Drax Bioenergy with Carbon Capture and Storage, PINS Reference: EN01012

Comments on responses to the Examining Authority's written questions and
Comments on any other responses received by Deadline 2.

Plate 2.1 - Process Block Flow Diagram for the Proposed Scheme

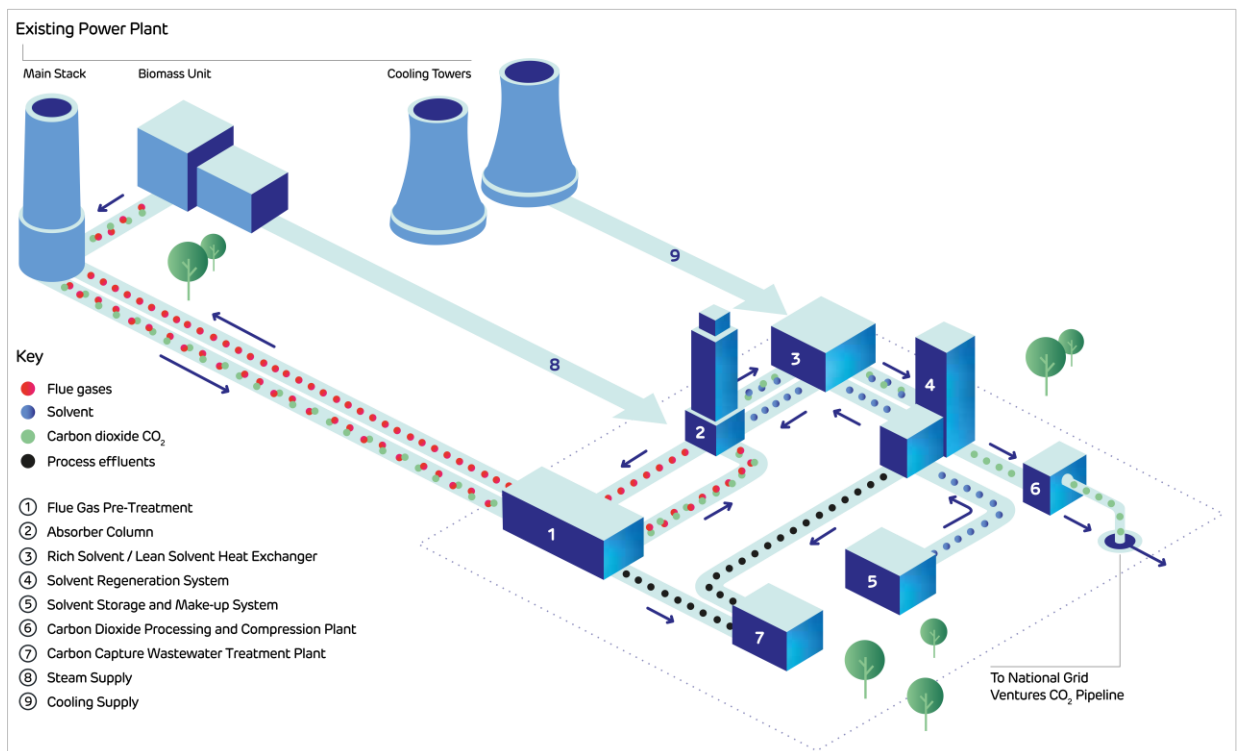
1. Particulates – there is no provision in the design for Electrostatic Precipitation Scrubbing (EPS) to remove fly ash and other particulates, yet the BAT guidance clearly states that this is a potential issue. Section 3.3.1 of the BAT guidance says:

Because of the claimed commercial confidentiality surrounding the proprietary solvent, we cannot know if there is a risk of fly ash and other materials building up in the solvent, and seek an explanation of this aspect of the proposed operation. It is reasonable to assume that there will be fly ash present in the flue gas stream, and we question why there appears to be no EPS designed in.

Section 3.6 of the BAT guidance is clear that capture rates need to average 95% during start-up and shutdown. The guidance says that the use of solvent storage has been identified in the BAT review as a method of improving capture rates, and that if the PCC plant is NOT designed with this facility, it must be possible to retrofit it. It is not clear to the lay person whether the current application includes this, either in the current DCO or as a potential further addition requiring planning permission. Clarity on this would be appreciated as well as whether the BAT suggested solvent storage process is designed in.
